RE: 6/2017/2625/COND – Plot 4100 Gypsy Moth Avenue, Hatfield Business Park, Hatfield, AL10 9UH

Thank you for re-consulting us on the above planning application for the Submission of details pursuant to conditions: 5 (details of new roads, accesses, cycleways and footpaths), 6 (Surface water drainage scheme), 7 (site investigation), 9 (Reptile Survey), 12 (details of floor lighting and external lighting) and 13 (details of open storage) on planning permission 6/2015/2043/OUTLINE dated 05/07/16, at Plot 4100 Gypsy Moth Avenue, Hatfield Business Park, Hatfield, AL10 9UH.

We advise the LPA that the information submitted in support of Condition 6 in relation to surface water does not demonstrate the proposed development site can be adequately drained. Therefore, we recommend to the LPA not to discharge Condition 6.

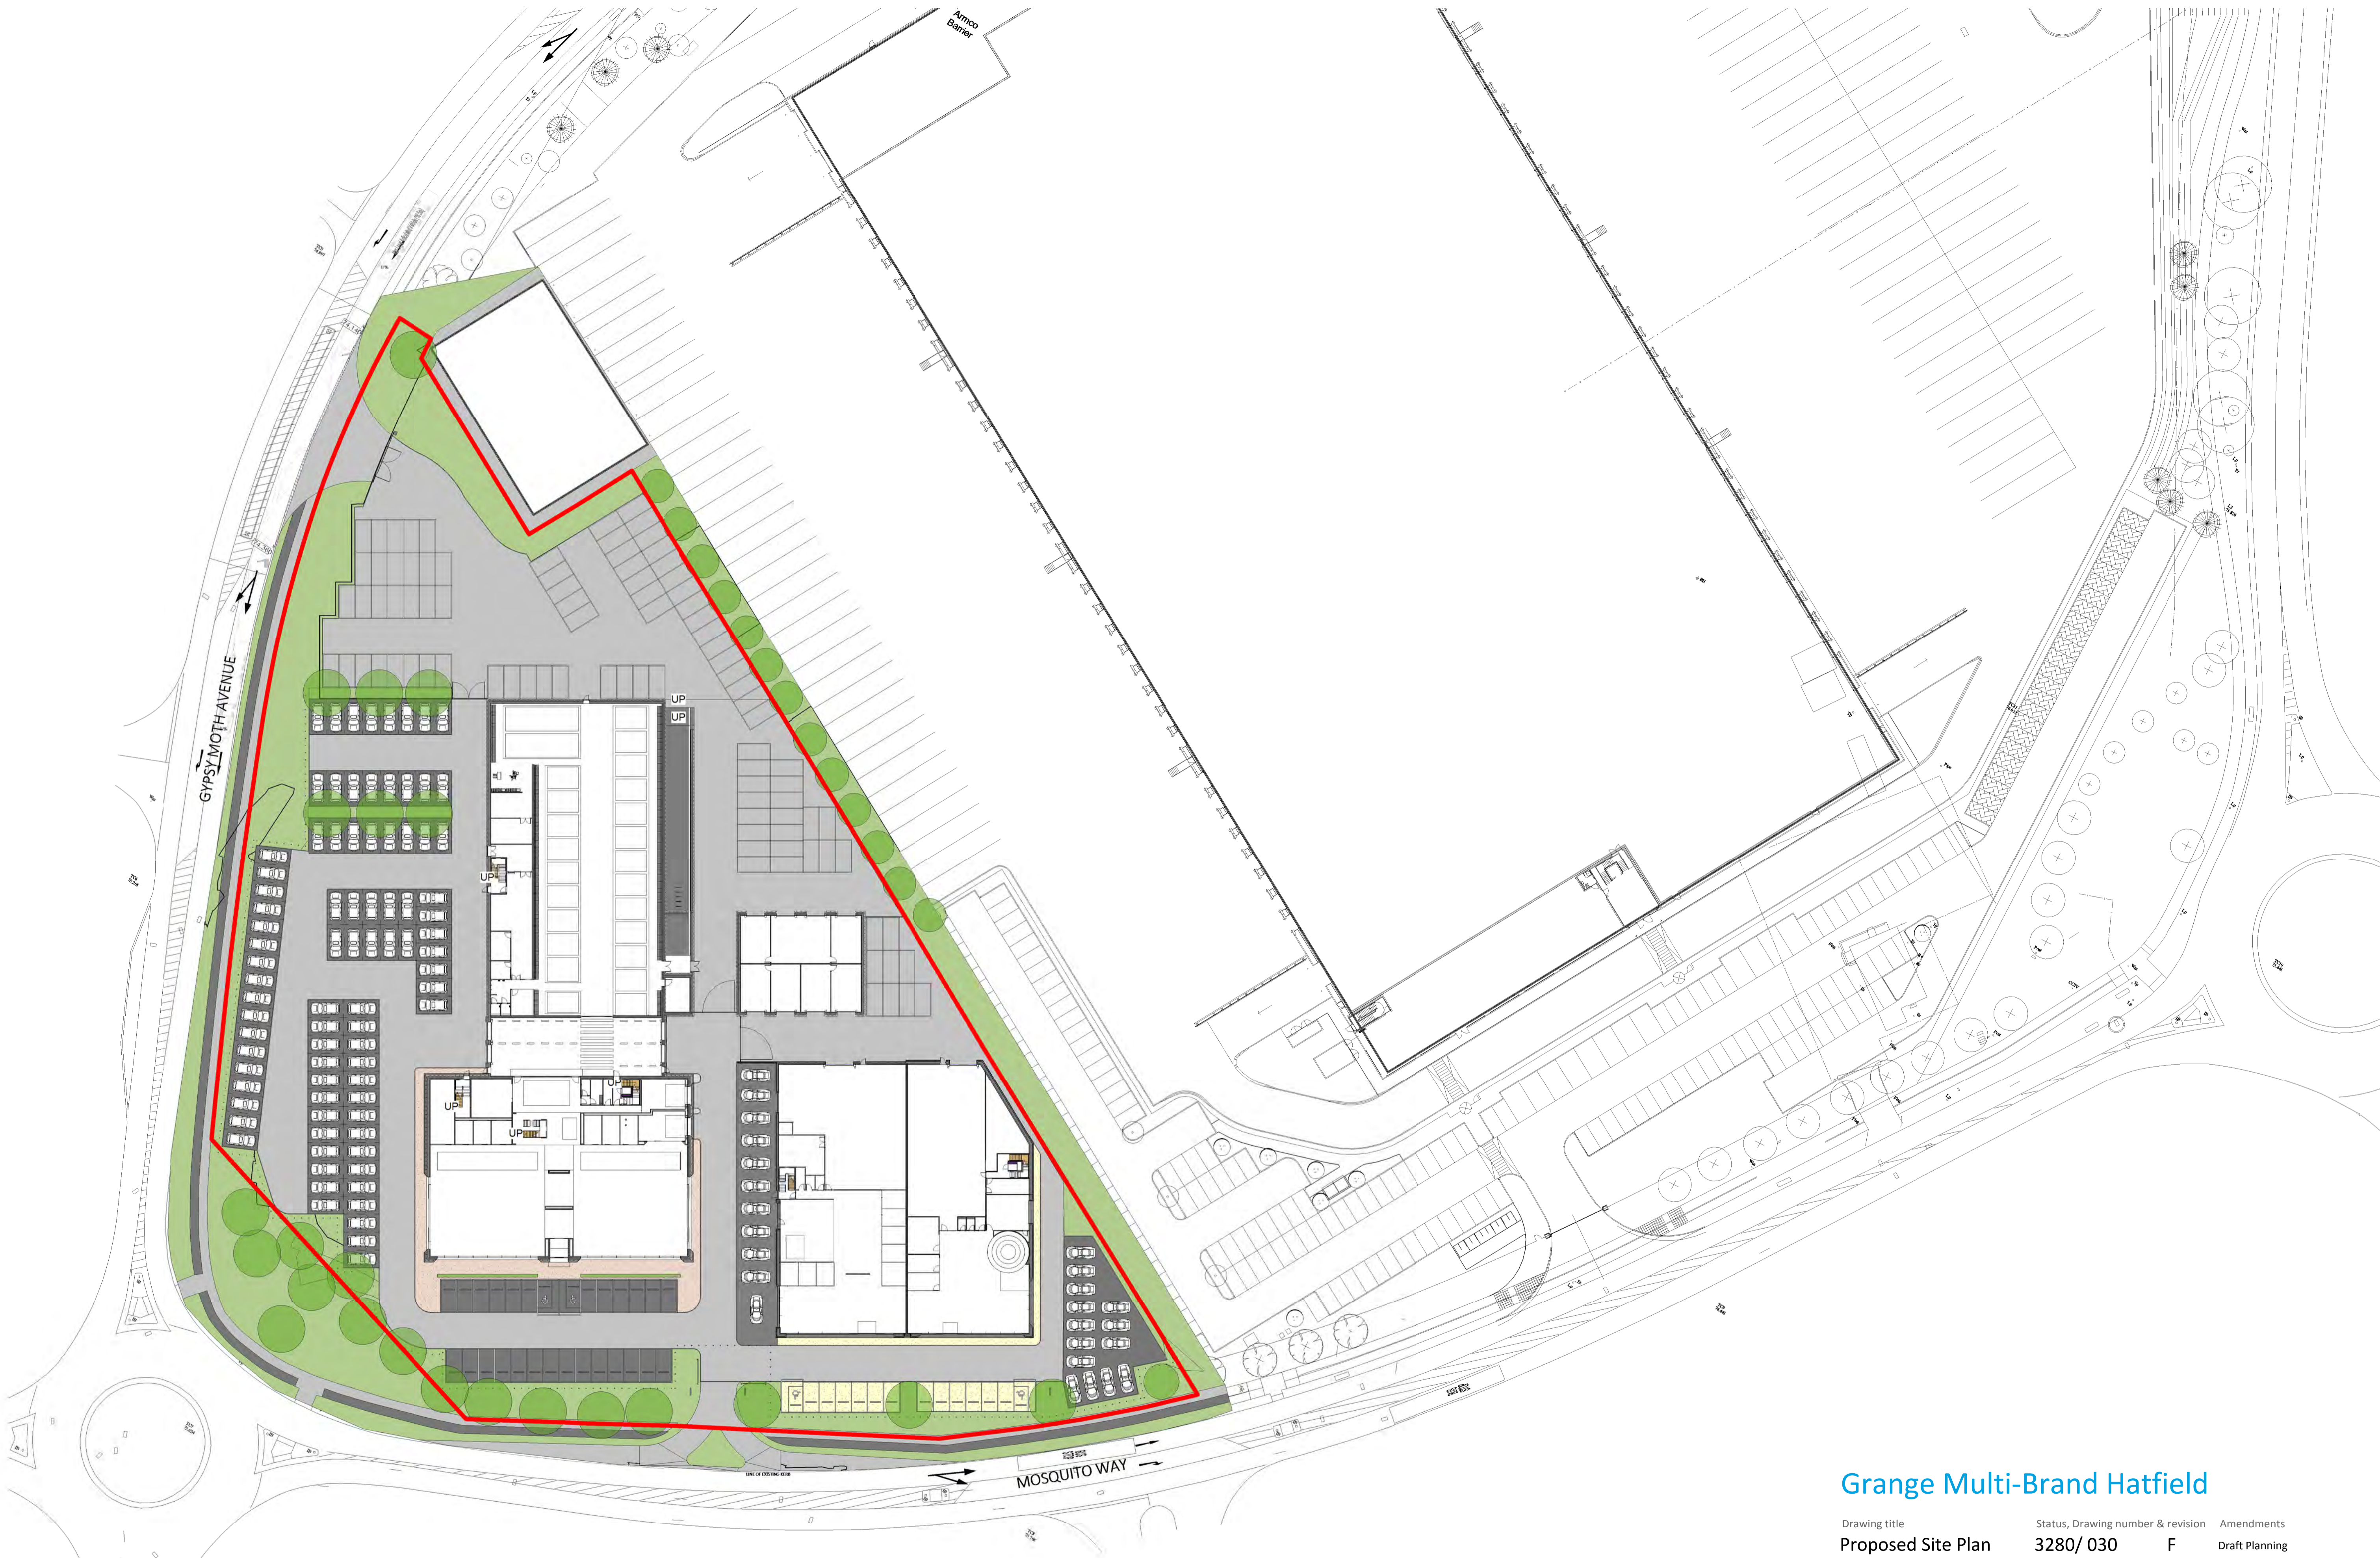
As this is a discharge of conditions stage, we would expect the applicant to provide a full detailed drainage strategy. Locations of the proposed SuDS features should not be assumed only.

The applicant should provide an explanation of the proposed drainage scheme and how it works. It is not clear whether the proposed attenuation tanks will be offline features.
